RE: SSD 6371 – 175-177 Cleveland Street, Redfern

I write in relation to the Department's email dated 9 October 2014 which referred to Response to Submissions regarding State Significant Development Application SSD 6371. This proposal is for a new mixed use development at 175-177 Cleveland Street, Redfern.

Reconciliation of Student Accommodation issues

ROOF GARDEN @ 1:200

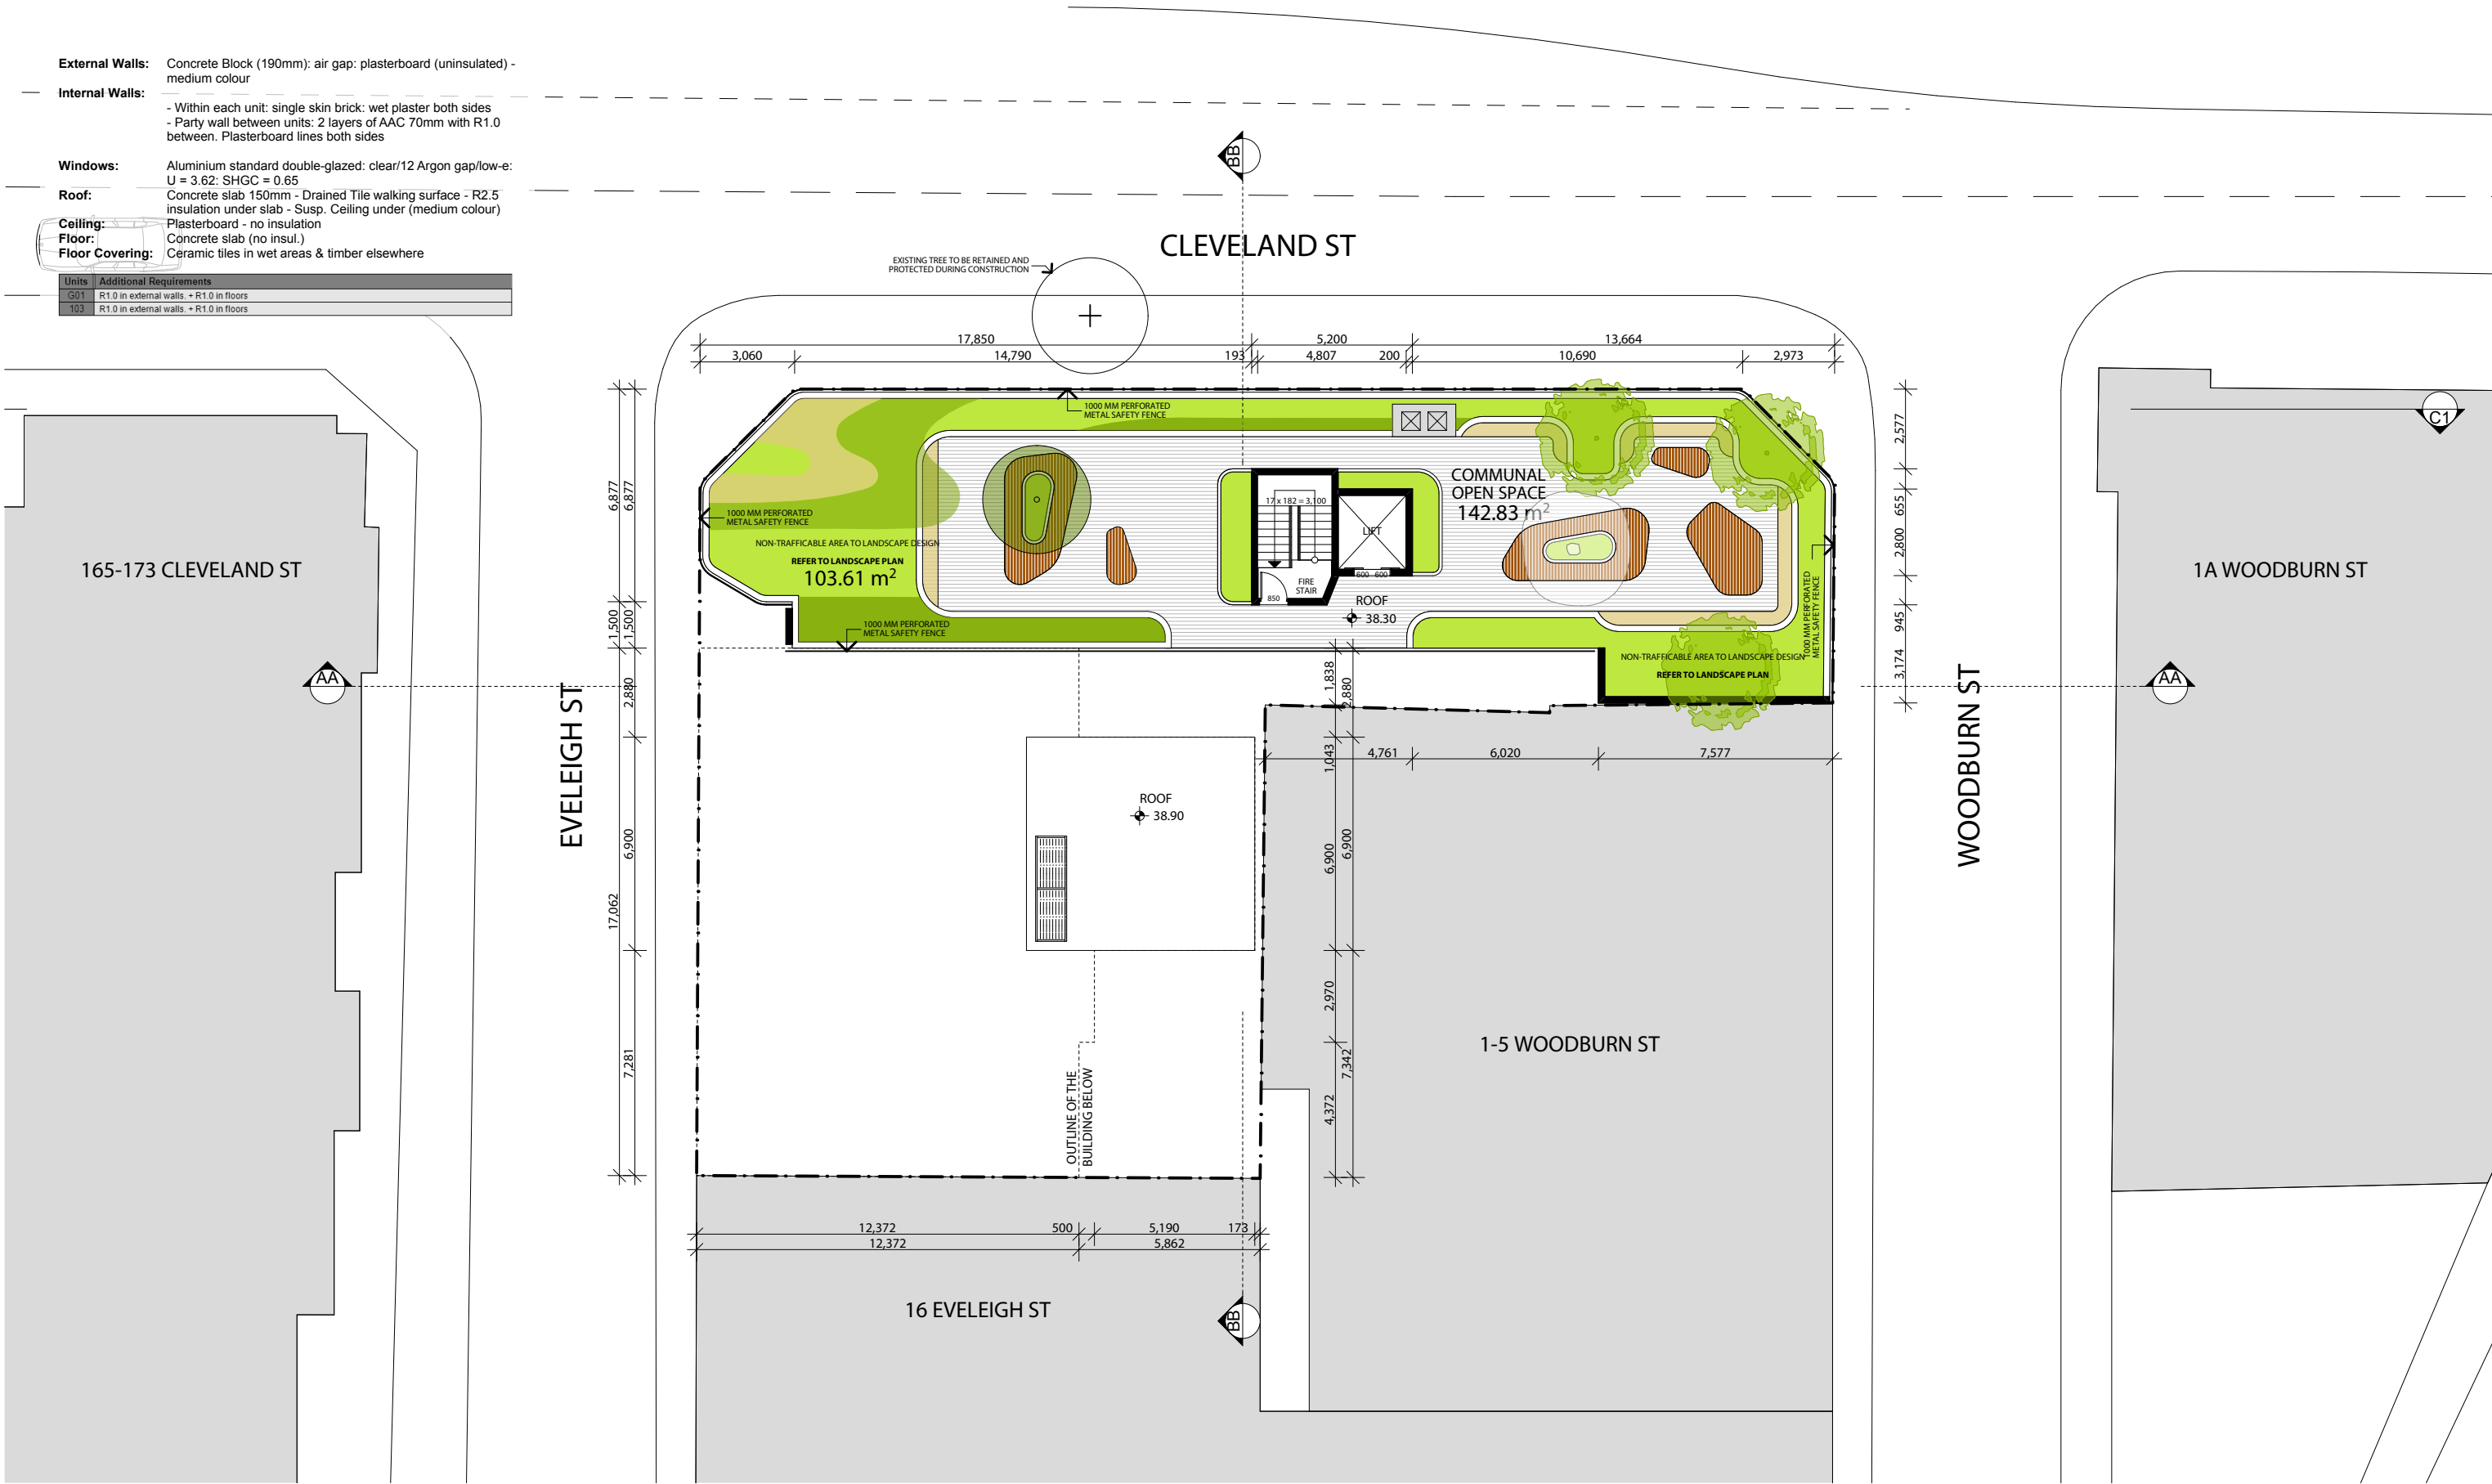
It is noted that planting is provided on the roof terraces in wide planter beds to deter access to the edge of the roof. However additional 1m high guarding should be provided on top of the parapet to protect from the additional fall height created by the garden bed, or an alternative arrangement of garden beds should be provided.	The architectural plans have been amended to provide an additional 1m high guarding on top of the parapet to protect from the additional fall height created by the garden bed.	Yes	N/A
Clarification should be sought regarding how the landscaped areas will be maintained. A maintenance plan including a method statement for working at height should be provided.	Maintenance of landscaping can be adequately addressed via a condition of consent and a maintenance plans is not necessary to inform the assessment of the development application.	Acceptable	The City recommends an appropriate condition regarding landscaping details be included to address this requirement.

NORTH ELEVATION @ 1:200

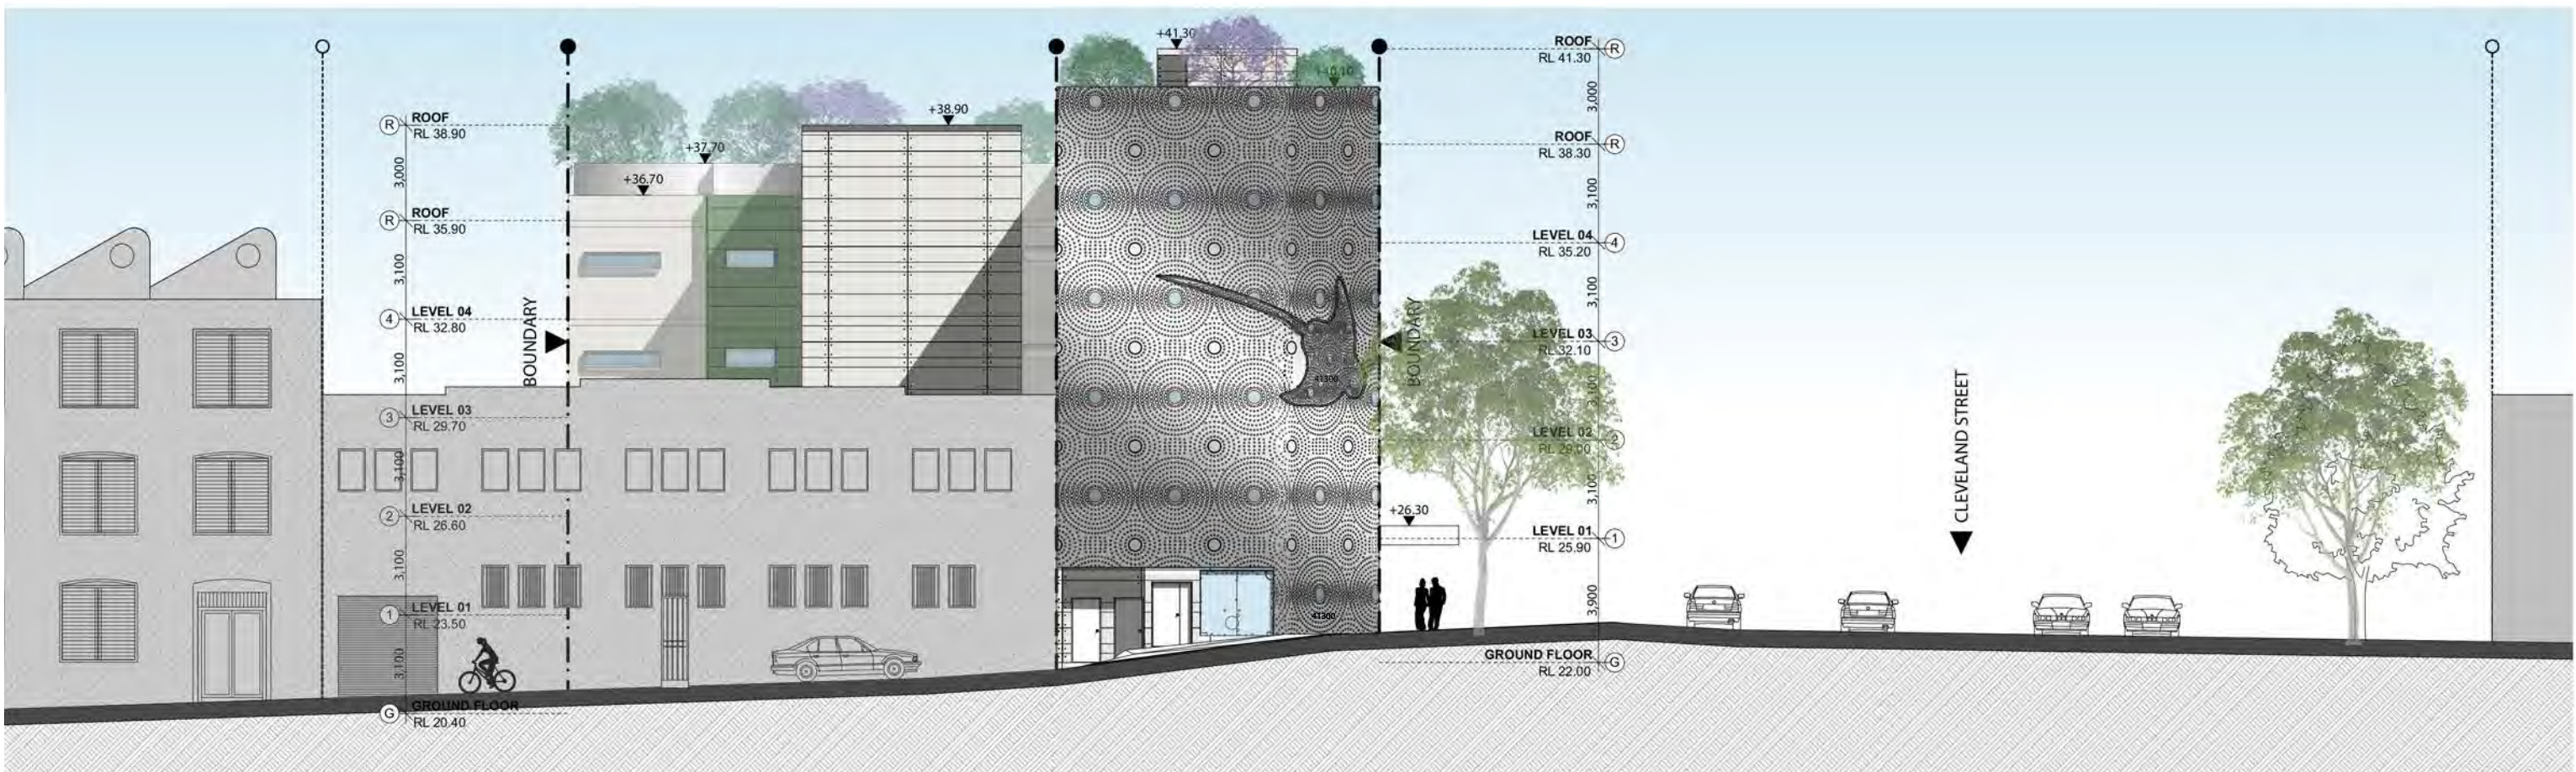
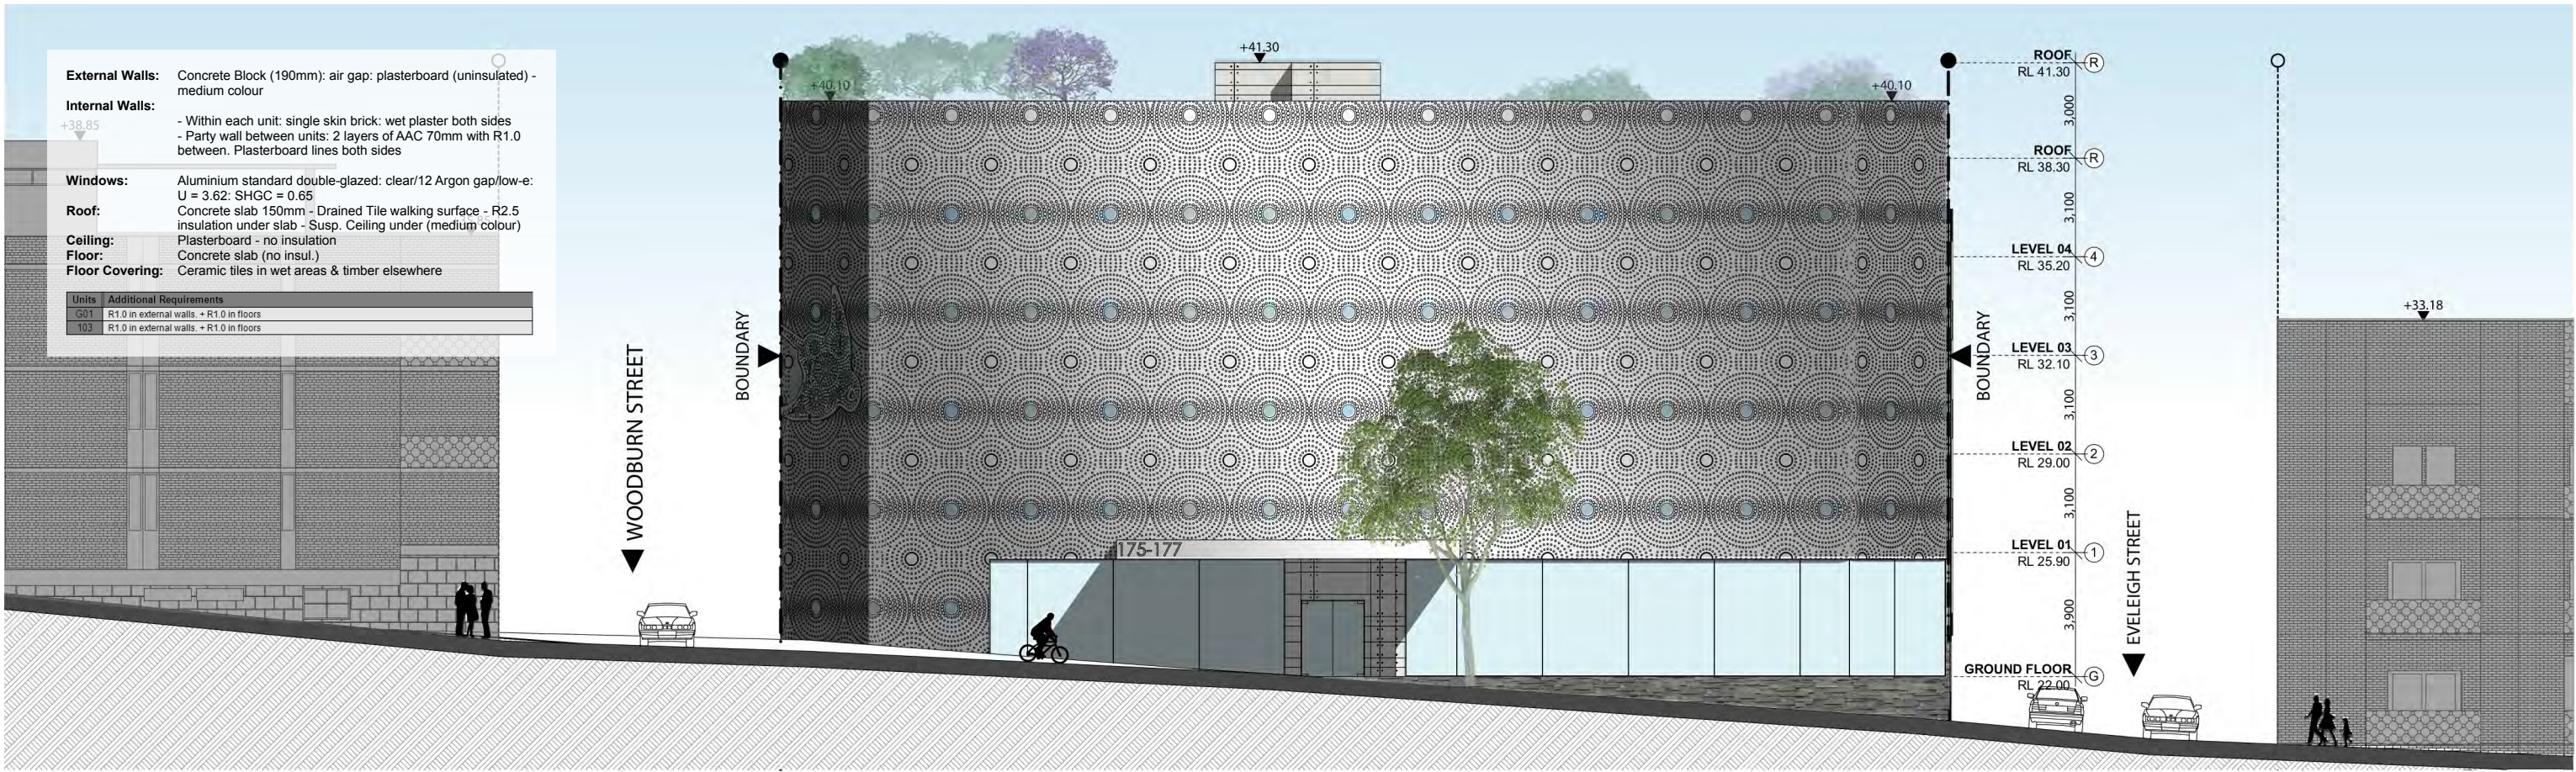
The ground floor Cleveland Street elevation comprises double glazed low E glazing. While the use of glazing in this location is supported, consideration should be given to the reliance of curtains or blinds to manage weather protection and privacy. An integrated blind system that does not result in visual clutter should be considered.	The ground floor of the Cleveland Street elevation is the reception and common room area for the student accommodation and is not a private area. It is intended that this space remain visible from the public domain to achieve a high level of street activation (similar to the ground floor of Council's Surry Hills library on Crown Street) and therefore curtains or blinds are not intended for this area.	Acceptable	N/A
It is noted that a plant room is proposed within the basement level and no plant has been located on the roof. Clarification should be sought as to whether any plant is to be located on the roof.	The roof tops are intended to provide generous common open space areas for the residents and students and will not contain plant. Sufficient area is provided in the basement for plant.	N/A	N/A
